Engineers Comments Regarding Surface Water Drainage

Application Reference:	AL/58/26/DOC	Reviewer Reference:	ADC/EXT5/AF
Planning Officer:	Hebe Smith	Date of Review:	27/07/2026
Site Name:	Stanwick Northfields Lane Westergate PO20 3UH		
Application Description:	Approval of details reserved by condition under AL/70/24/HH relating to condition 3- Surface Water Drainage.		
Assessment Number:	1

Application Reference: AL/58/26/DOC Site Name: Stanwick Northfields Lane Westergate PO20 3UH	Initial Issue Date: 21/10/2024 Issue Date: 27/07/2026 Reviewer Reference: ADC/EXT5/AF
---	---

- FLOW CONTROL CHAMBER (MH4) – ANTI-BLOCKAGE AND MAINTENANCE REQUIREMENTS
1. FLOW CONTROL DEVICE: PROVIDE HYDRO-BRAKE® OPTIMUM (OR APPROVED EQUIVALENT) SIZED FOR $Q = 0.30$ L/S AS INDICATED ON THIS DRAWING.

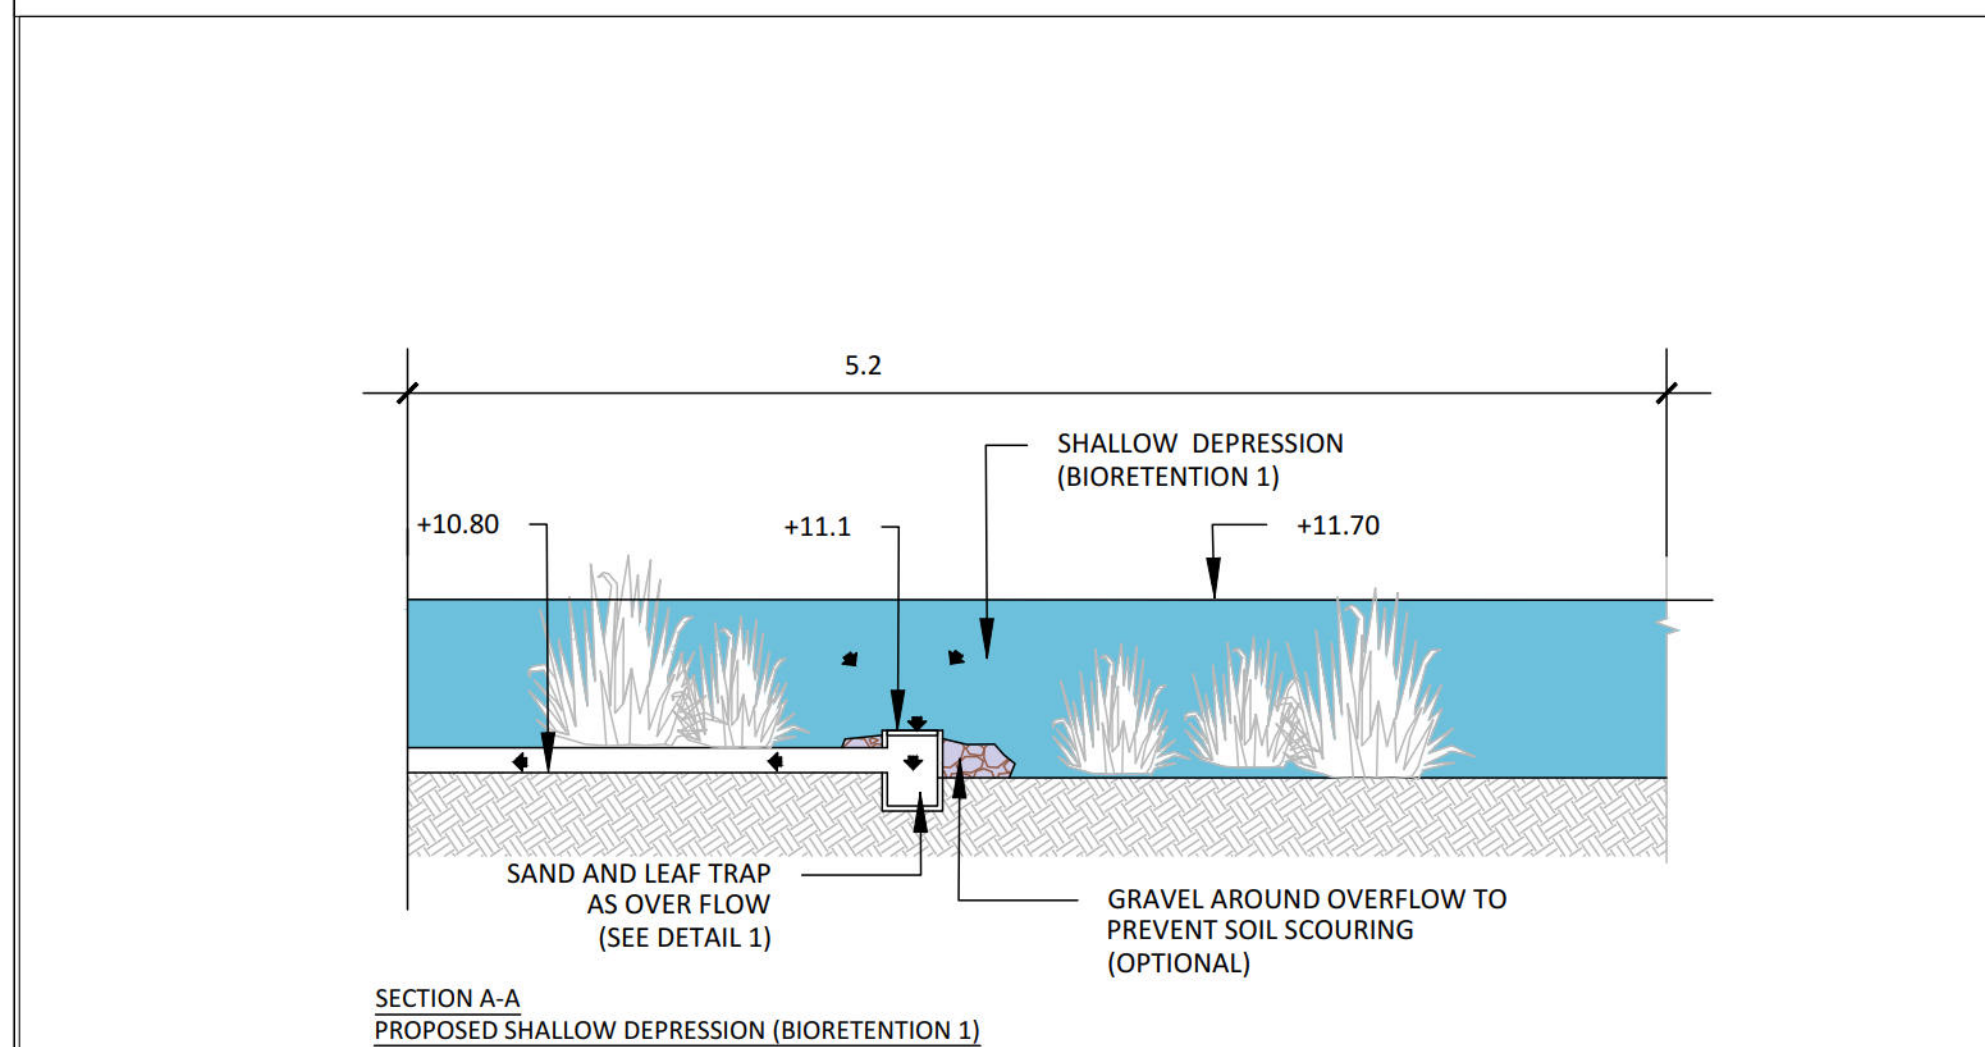
11.	Please submit construction detail drawings for all components – see checklist. ADC Drainage Comments 16/02/2026	Please submit construction detail drawings for all components – see checklist. Particular attention should be paid to the flow control chamber and incorporating	See DS FRADS Giles Vos Rev 03 Appendix E Surface Water Drainage Strategy 1 of 3 24502-ENV-ZZ-00-DR-D-1000	Comment closed.

Please submit construction detail drawings for all components – see checklist. Particular attention should be paid to the flow control chamber and incorporating blockage protection within and upstream as the flow control device size is highly susceptible to blockage.	blockage protection within and upstream as the flow control device size is highly susceptible to blockage. Please confirm that all pipes can be easily and safely inspected accessed from the proposed chambers. The type of construction appears to obscure visibility and access of some pipes from surface level, and they do not appear to be suitable for entry.	Silt traps are upstream of the flow control chamber. manholes provide access points for rodding. See DS FRADS Giles Vos Rev 03 Appendix F and G Surface Water Drainage Strategy 2 and 3 of 3 24502-ENV-ZZ-00-DR-D-2000 and 24502-ENV-ZZ-00-DR-D-3000 for construction details
